STATE OF NORTH CAROLINA  
DEPARTMENT OF TRANSPORTATION

July 6, 2022

Subject: **Revised Modification Request for Section 404 Individual Permit, Section 401 Water Quality Certification and Neuse Riparian Buffer Authorization** for Interstate 40 Widening and Improvements from I-440/US 64 (Exit 301) to just north of SR 1525 (Cornwallis Road), including improvements to NC 42 and SR 1010 (Cleveland Road) in Wake and Johnston Counties, Federal Aid Project No. IMNHF-040-4(139)301; TIP Numbers I-5111 and I-4739, Division 5. Debit \$570 from WBS Element 42346.3.1.

PROJECT REFERENCE NO.	SHEET NO.
1-5111/1-4739	17
R/W SHEET NO.	
ROADWAY DESIGN ENGINEER	HYDRAULICS ENGINEER
INCOMPLETE PLANS DO NOT USE FOR R/W ACQUISITION	
DOCUMENT NOT CONSIDERED FINAL UNLESS ALL SIGNATURES COMPLETED

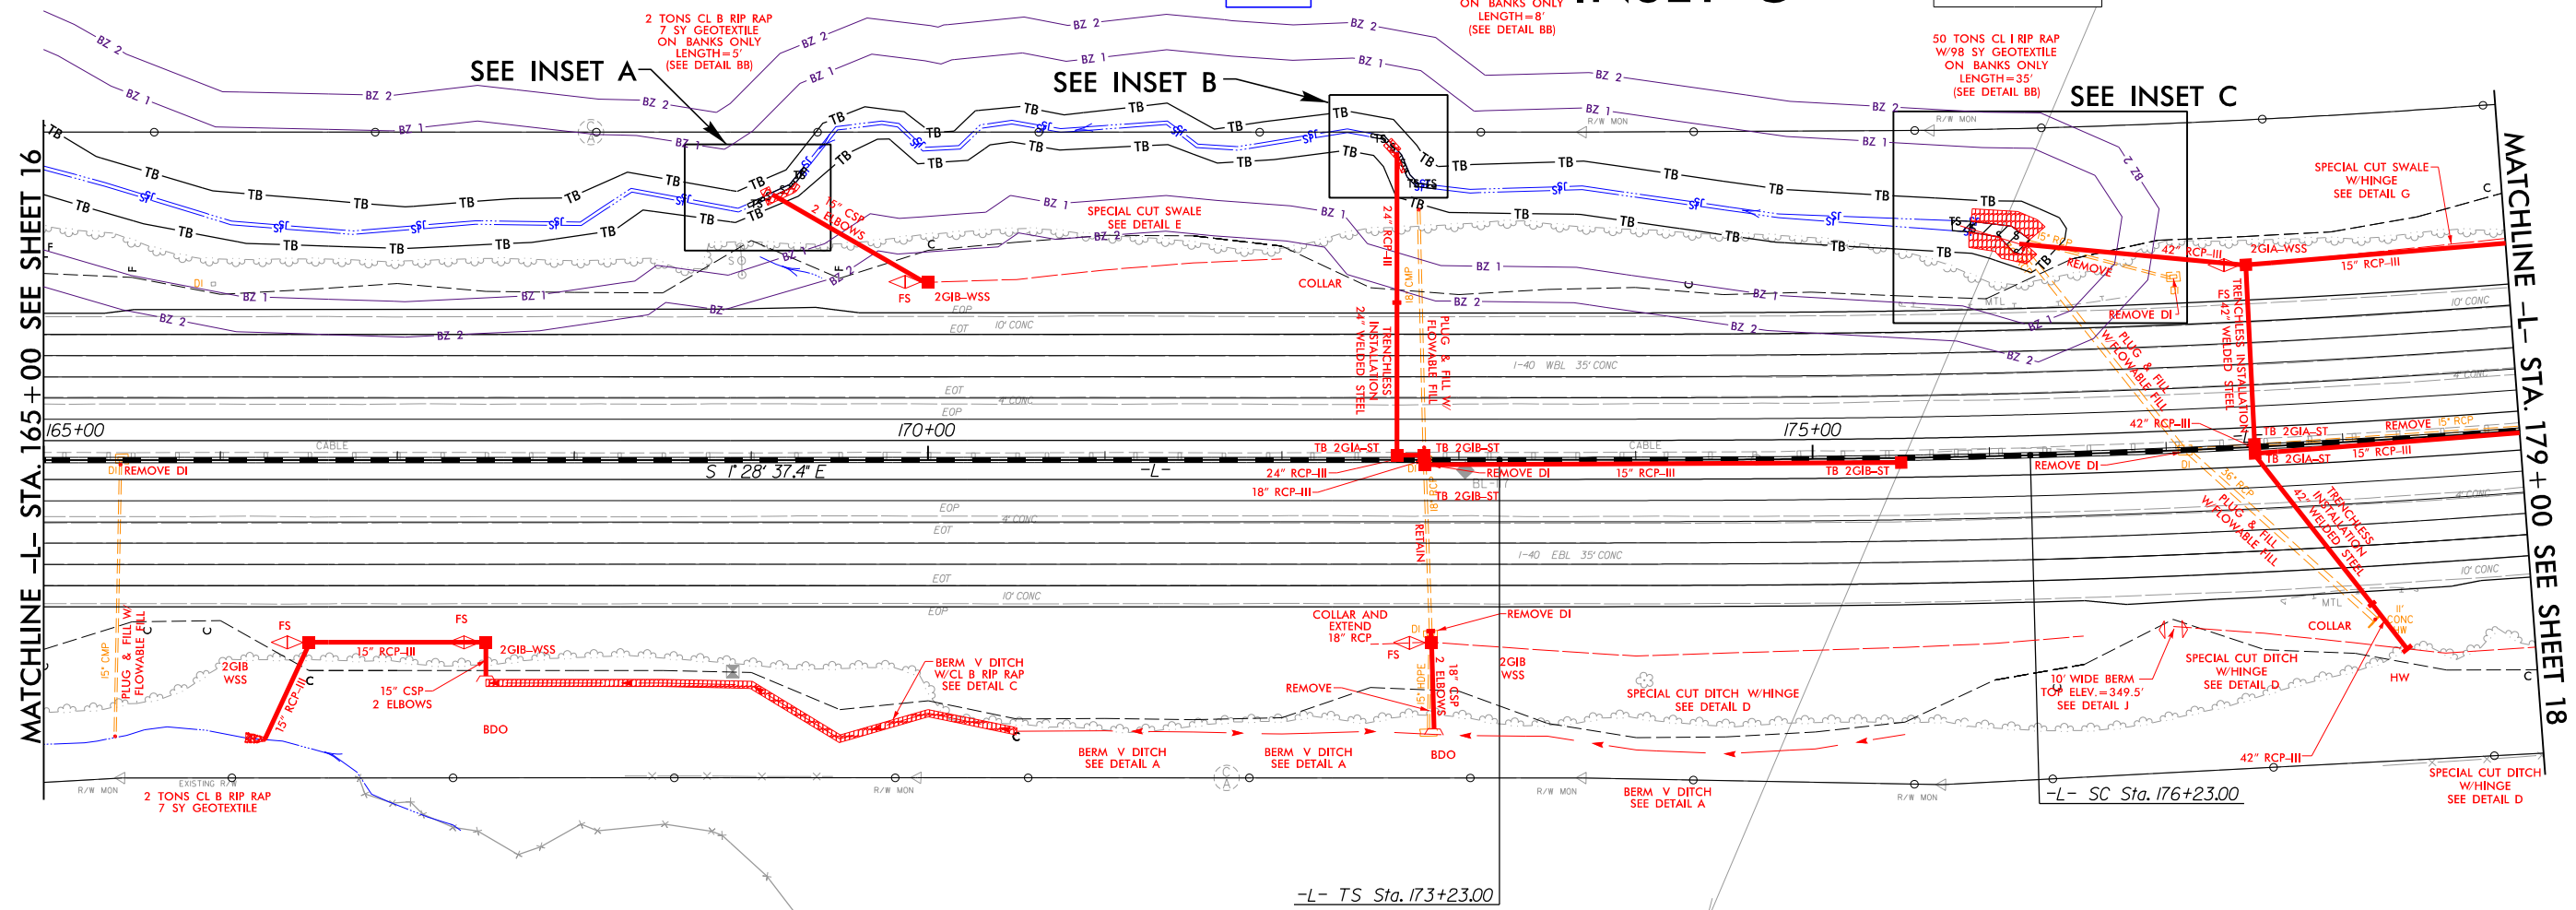
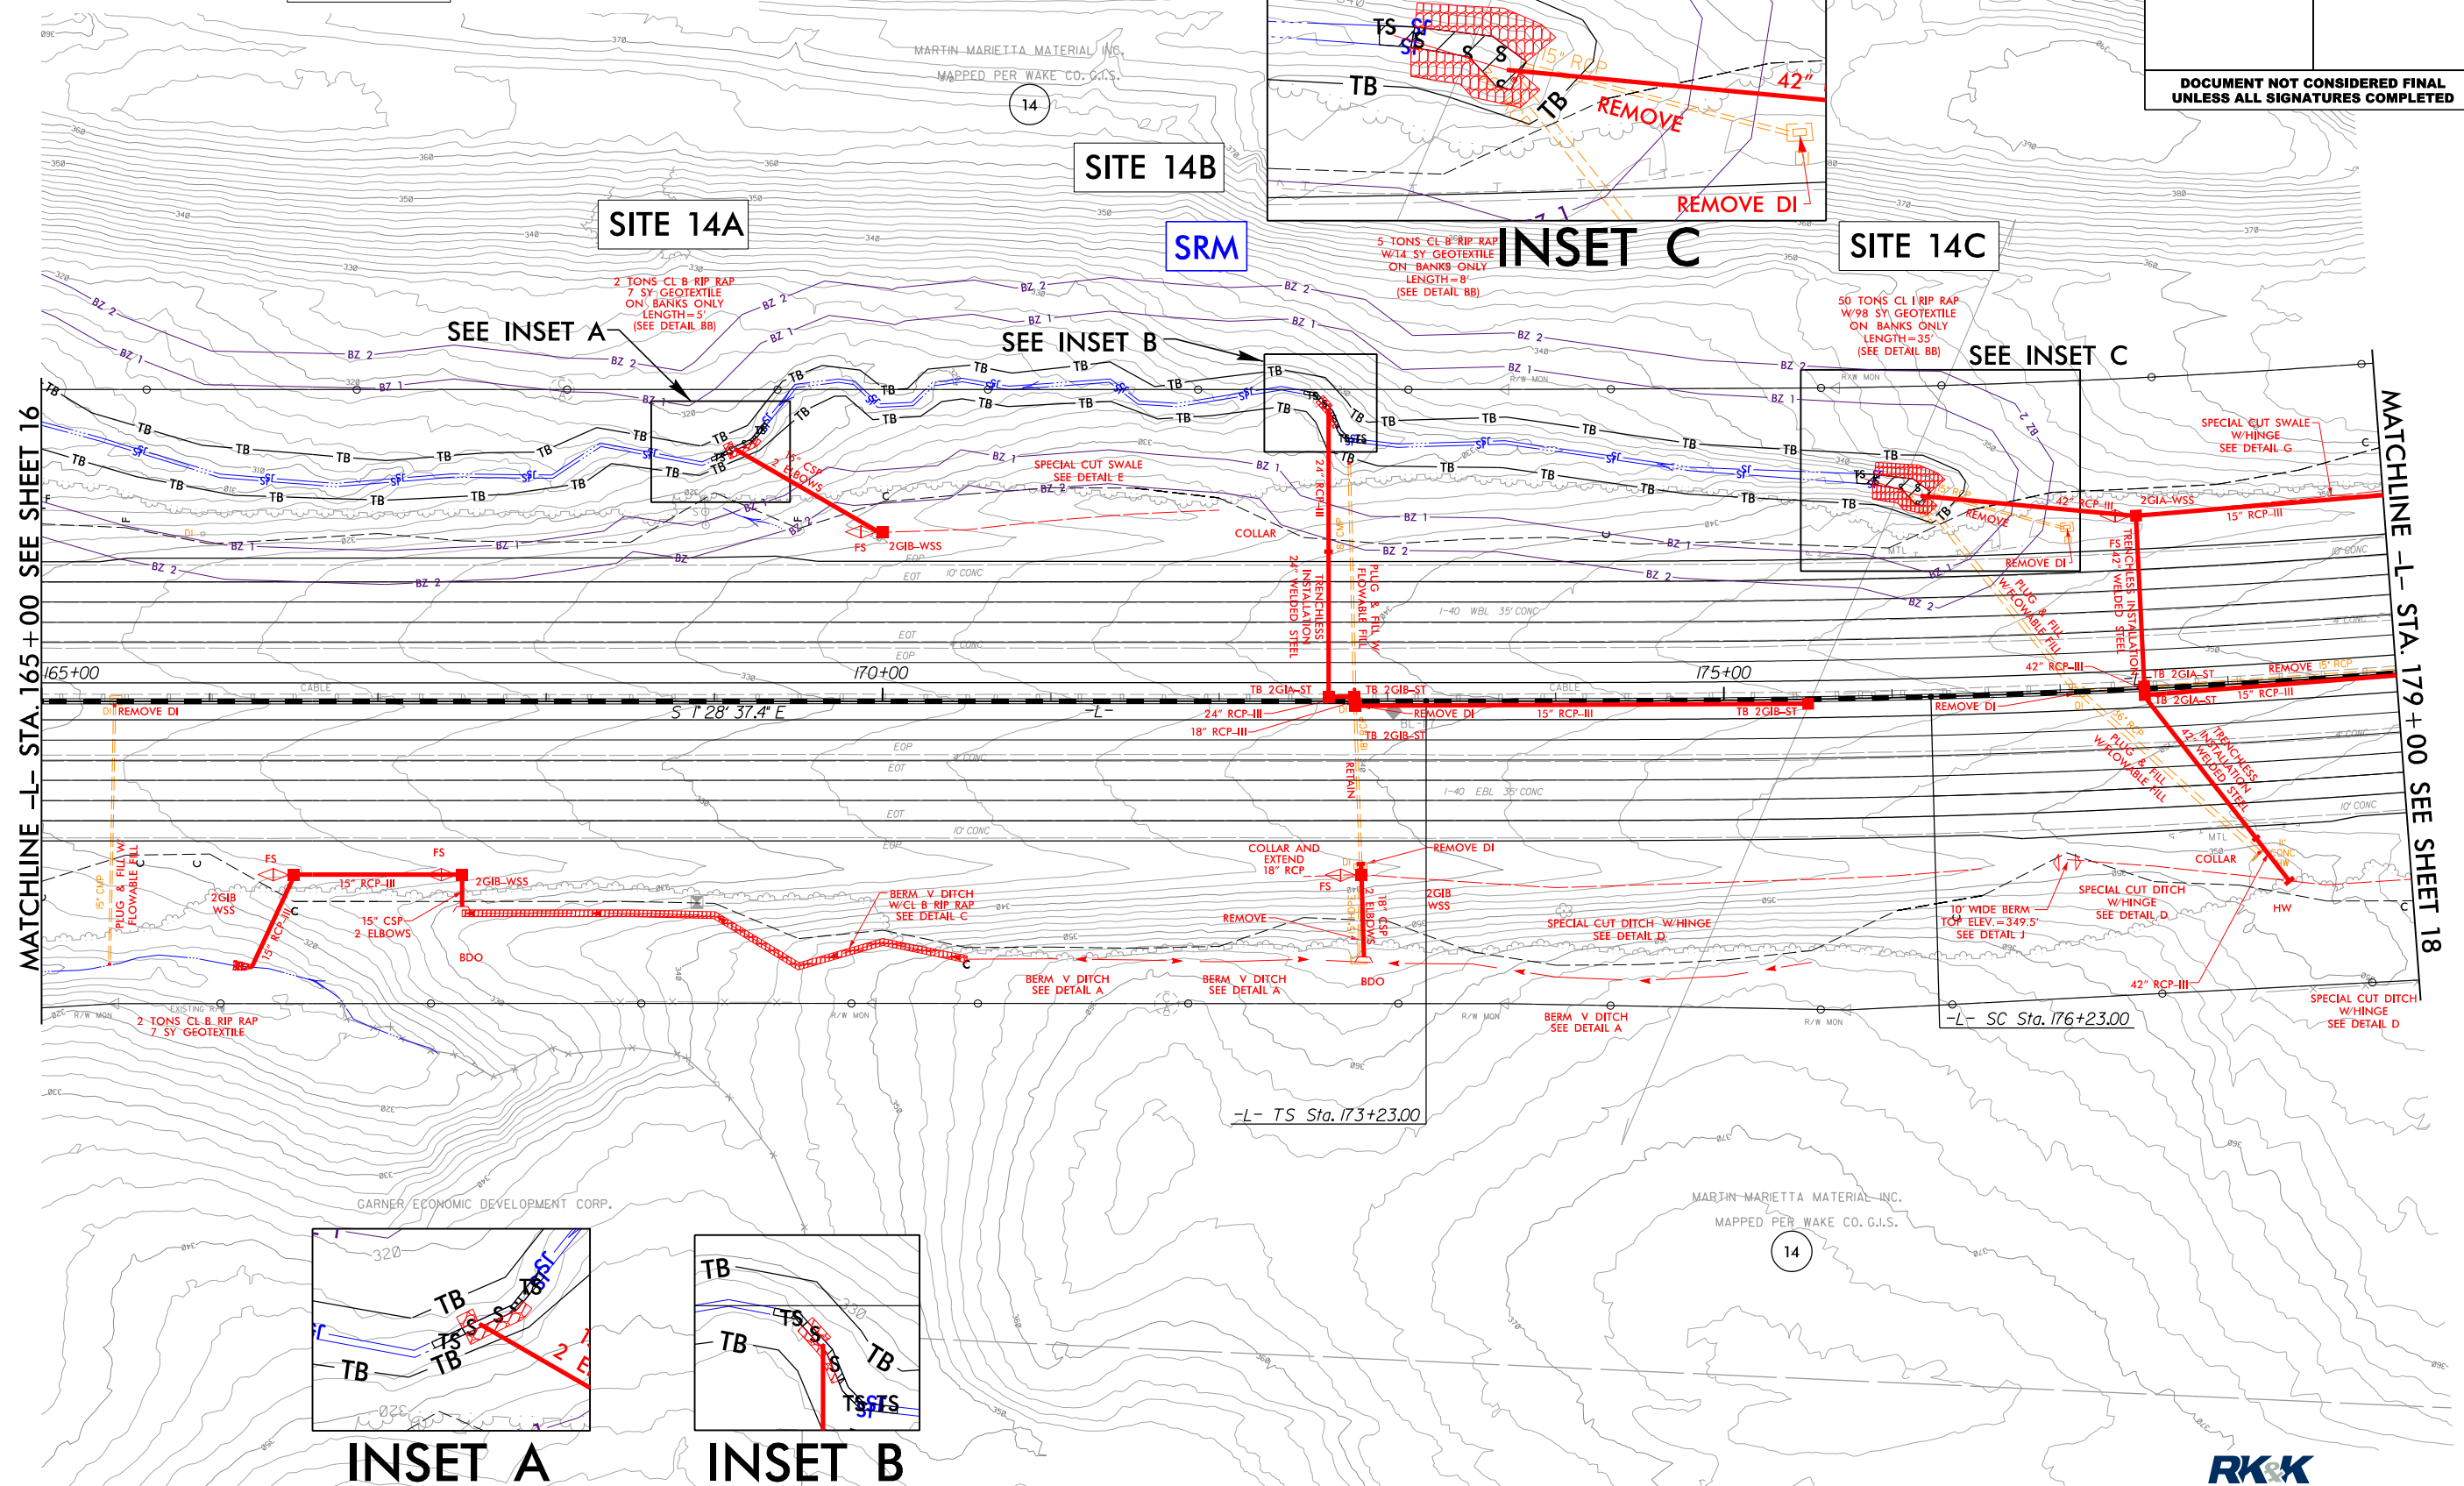
Site 14A: The pipe was installed at this site on June 22<sup>nd</sup>, and field conditions dictated that additional bank stabilization is needed. NCDOT asked that rip rap be placed upstream of the pipe outlet, in addition to the bank stabilization that was originally permitted. This change will result in the following changes in impacts:

- 15 linear feet increase in permanent stream impacts (bank stabilization)
- 400 square feet increase in mitigable buffer zone 1 impacts
- 186 square feet increase in mitigable buffer zone 2 impacts

Site 14B: Similar to site 14A, the pipe installation at this site requires additional bank stabilization upstream of the new pipe. This is in addition to the originally permitted bank stabilization below the new pipe. This change will result in the following changes in impacts:

- 12 linear feet increase in permanent stream impacts (bank stabilization)
- 12 linear feet decrease in temporary stream impacts (bank stabilization)
- No changes in buffer impacts.
